Barlings Beach – PPG response to submissions in response to Stage 2 Section 96 Application Amendment 5

BARLINGS BEACH REVISED SUBDIVISION - STAGE 3

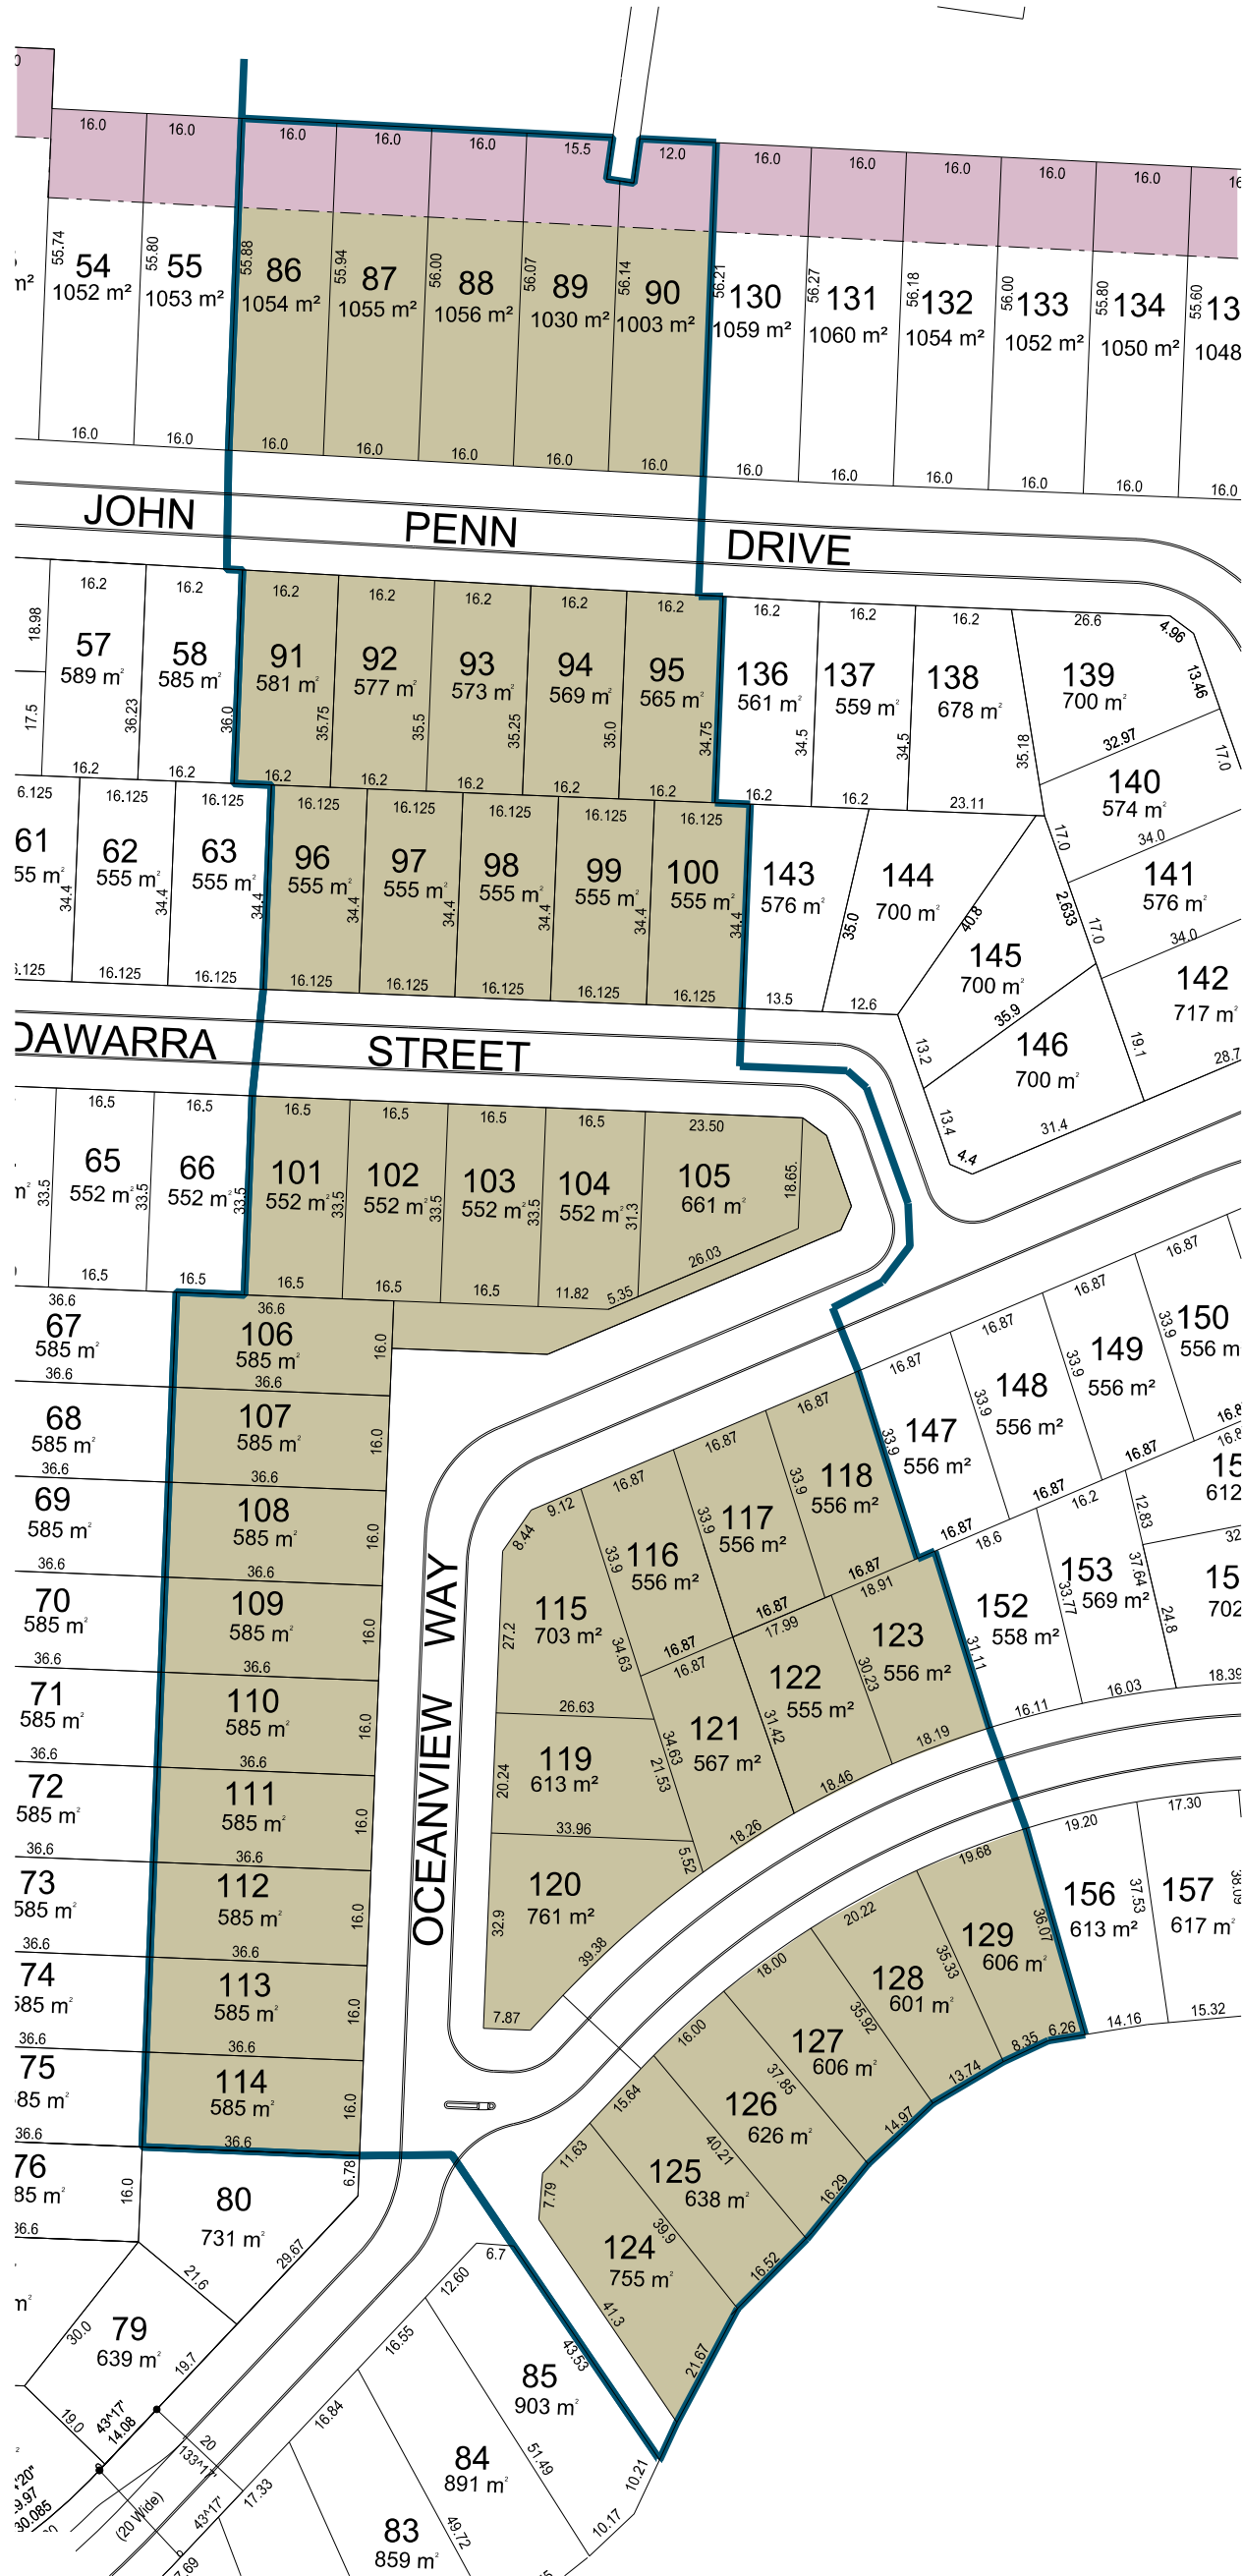
Department of Planning	
There is some concern regarding the viability of the SEPP 26 Littoral Rainforest, given that the vegetation at the base of the escarpment (currently approved to form part of the northern conservation area), which includes coastal Banksia/Eucalypt forest– provides protection to the rainforest from onshore winds. Removal of vegetation at the base of the escarpment for APZ purposes has the potential to remove the “protective” function of the vegetation, and may lead to changes to the composition and quality of the SEPP 26 Littoral Rainforest. A drier type of vegetation on the slope would be more susceptible to fire, endangering the houses on the top of the escarpment. It is considered that to provide an adequate buffer to the SEPP 26 vegetation, that “new” allotments 54 to 135 be reduced in length by a further 10 metres. Please submit amended plans identifying this.	The land has an approval for a 30m APZ within the northern conservation area. The submitted application reduces the land affected by the approved APZ by 10m and thereby increases the extent of undisturbed flora in the northern Conservation Area. In addition, following discussion with the Department of Planning, the proposal has been amended to further reduce the land affected by the proposed APZ proposed within the proposed ‘new’ allotments 54 to 135 by an additional 10m. Further, in response to the matters raised in relation to clearing arising from land designated as an APZ, and following further discussion with the RFS and PPG’s bushfire consultant Matt Jones, the extent of the APZ within the allotments has been reduced to 15m. See enclosed amended drawings and letter dated 21 June 2010 from Matt Jones.

BARLINGS BEACH REVISED SUBDIVISION - STAGE 3 (setbacks)

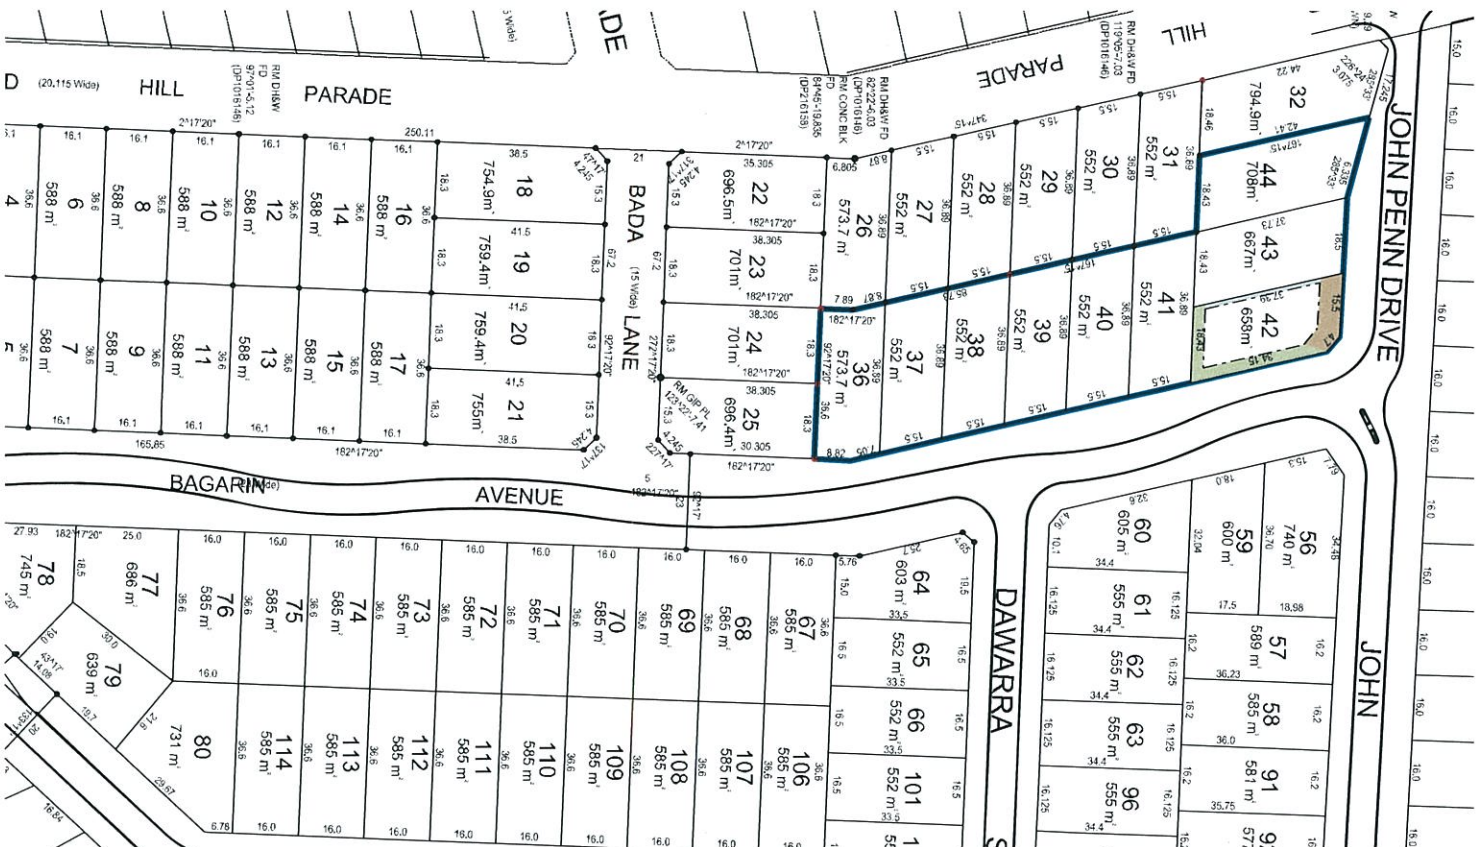
Eurobodalla Shire Council	PPG Response
Side Setbacks Proposed side setbacks should be consistent with Council's Current Development Control Plan and Draft DCP - being 3 metres. Council has advised that if the setback is required to be varied, then it should be done so at with a Development Application. Any development application seeking to vary the side setback to 2 metres, should demonstrate severe site constraints which would compromise the proposed development.	Noted. Will advise applicants and purchasers accordingly.
Section 94 Contributions (subdivision) At the time of issue of a Subdivision Certificate the applicant shall pay Council contributions per additional lot at the rate current at the time of payment under Section 94 of the Environmental Planning and Assessment Act 1979, applies to this subdivision in relation to the following: * Open Space and Recreation \$339.15 * Waste Facilities \$107.75 * Cycleway and Pedestrian Facilities \$29.25 * Administration \$87.65 * Arterial Roads \$2422.25 Note: The above contributions are reviewed at least annually and may be subject to increases as a result of indexation or other forces. Water and Sewer Headworks Pursuant to Section 64 of the Local Government Act 1993 payment to Council of headworks charges per additional allotment as follows: Sewer Headworks \$8865.00 Water Headworks \$10185.00 Note: The above contribution rates are applicable for a period of 3 months from the date of this notice. If not paid within this time contributions are to be paid at the time of issue of subdivision or occupation certificate at the rates applicable at that time.	Noted.
